Our Ref: BR/18/18/PL
Your Ref:

Town & Country Planning Act 1990 (as amended)
Town and Country Planning (Development Management Procedure) (England) Order 2015
Application for Planning Permission

Development Change of use from garage & vehicle hire company to vehicle hire branch including the demolition of existing building to replace with modular unit. This application may affect the setting of a listed building.

Location Bruce Dixon South Bersted Garage Shripney Road Bognor Regis

Drawing: Proposed Site Plan

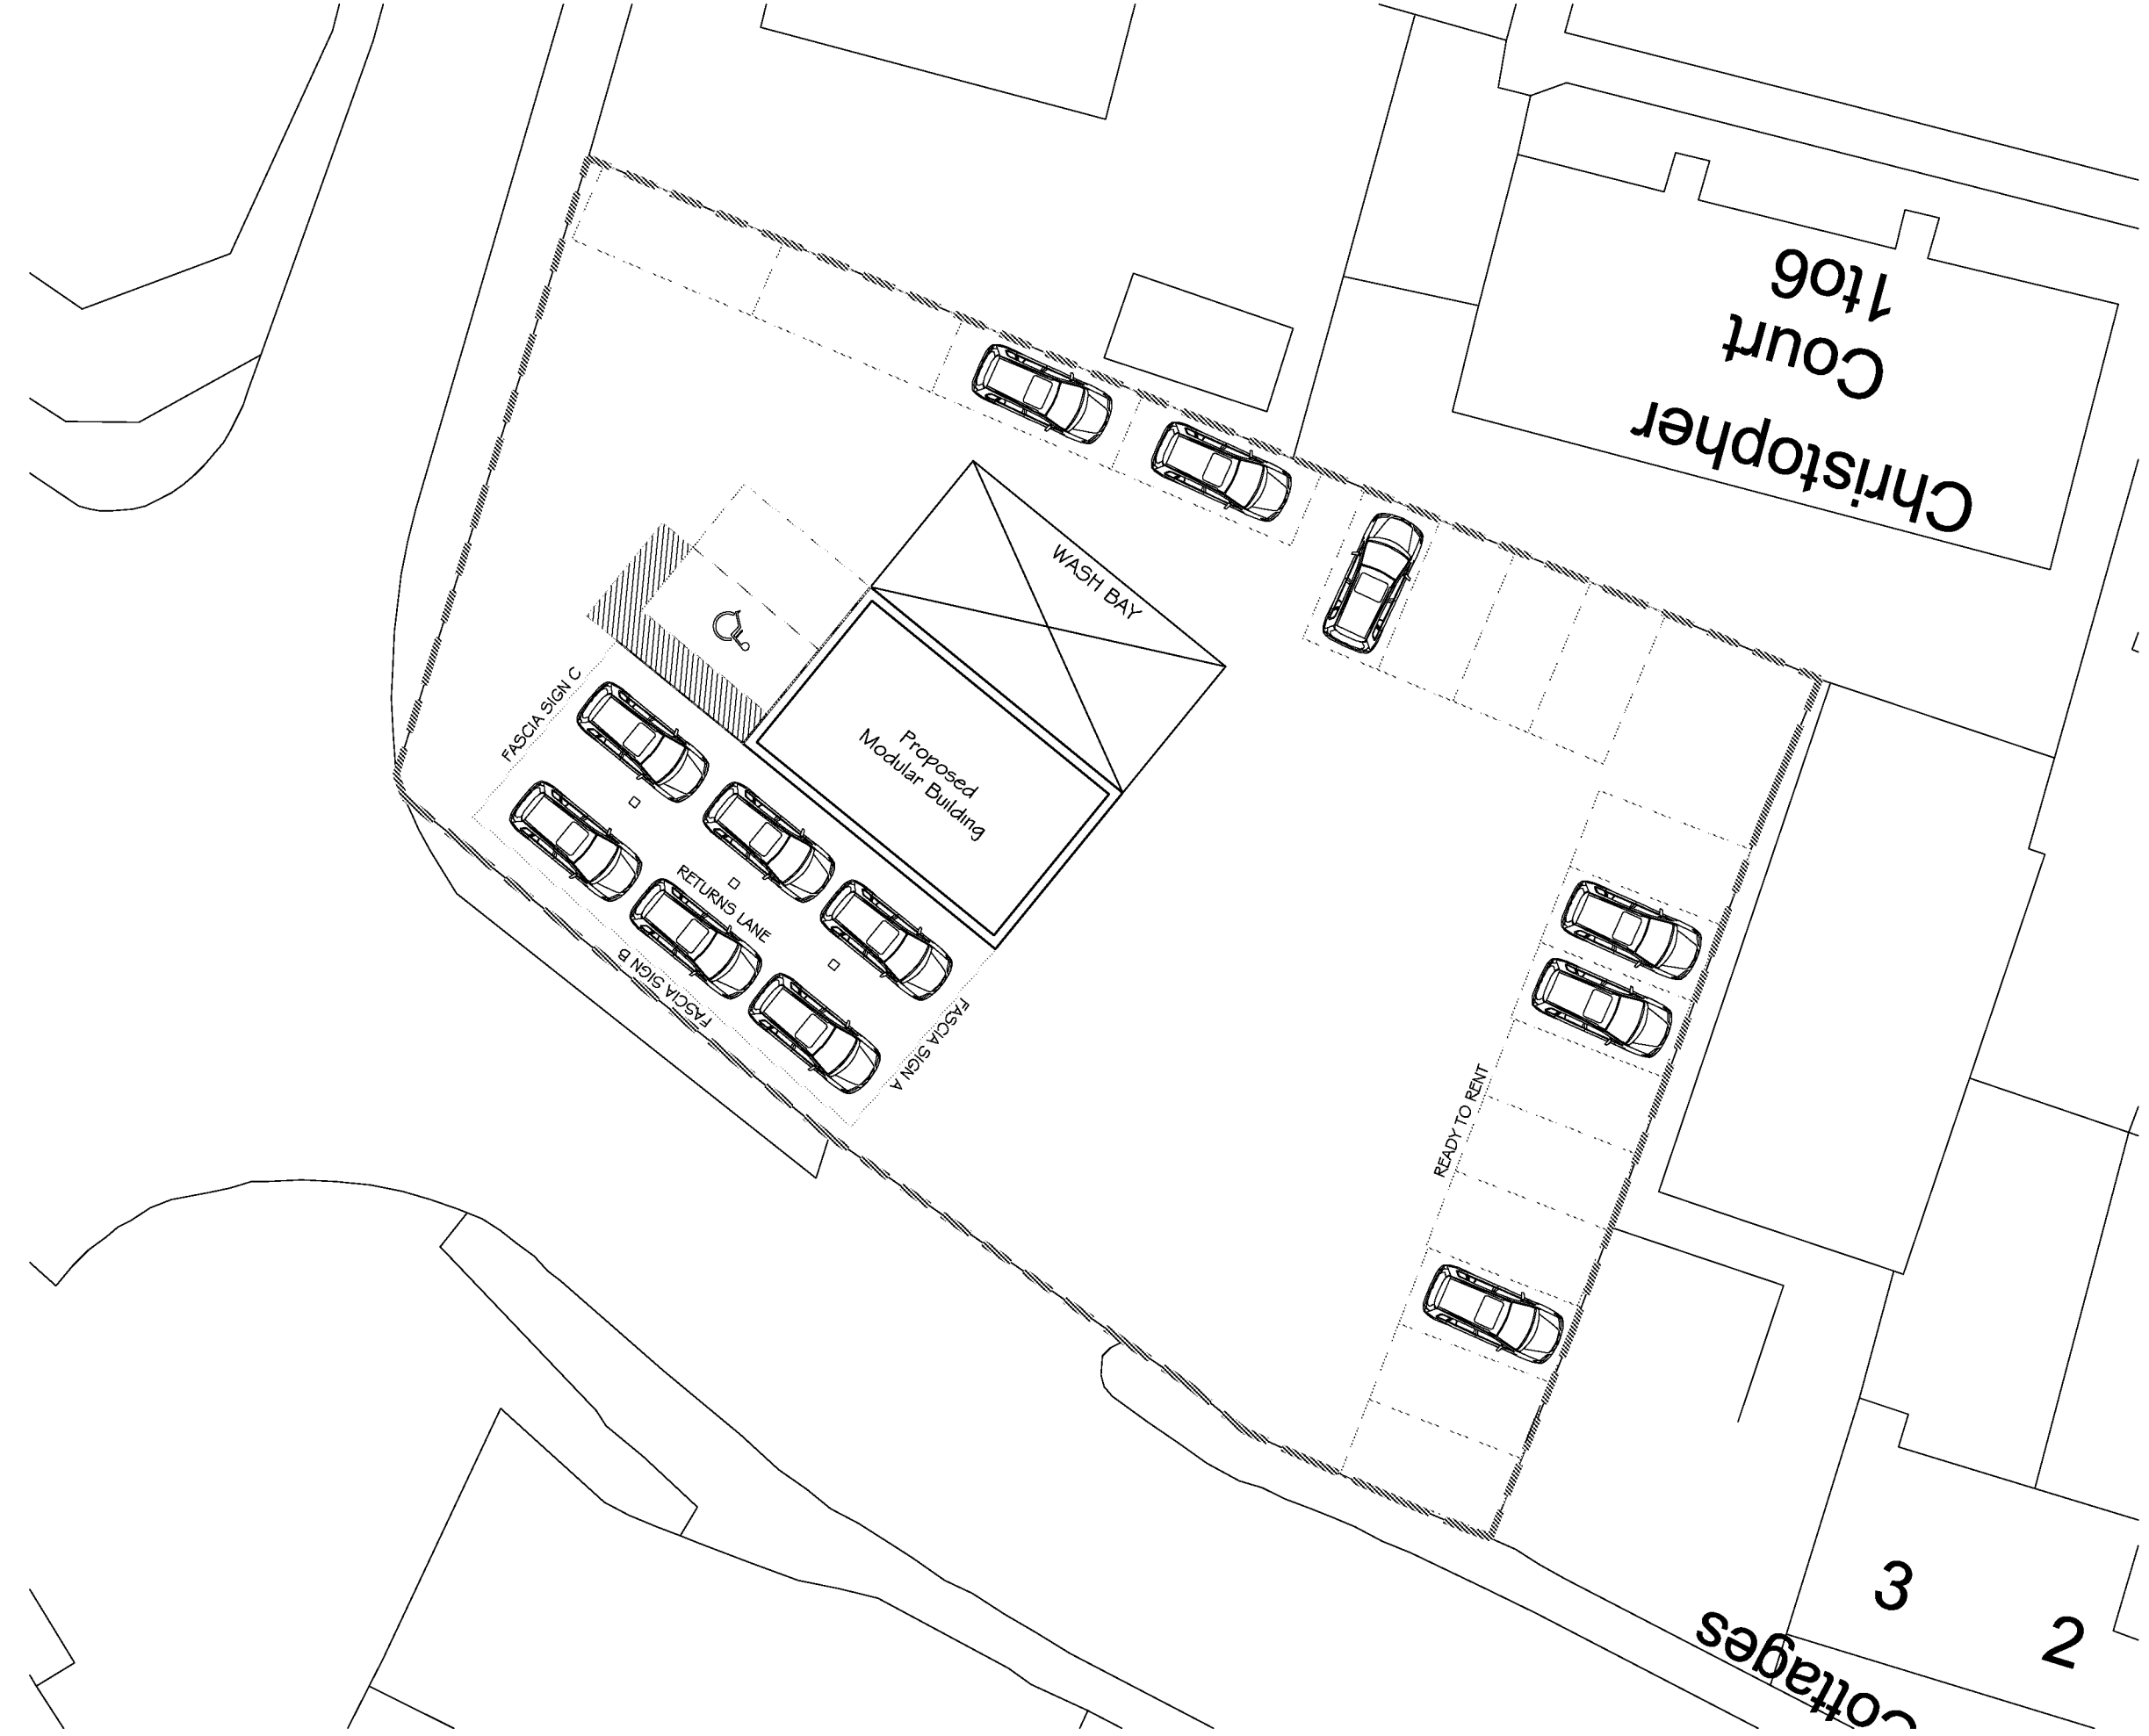
On the proposed site plan, please indicate that the canopy is to be retained.
Flood Risk Assessment
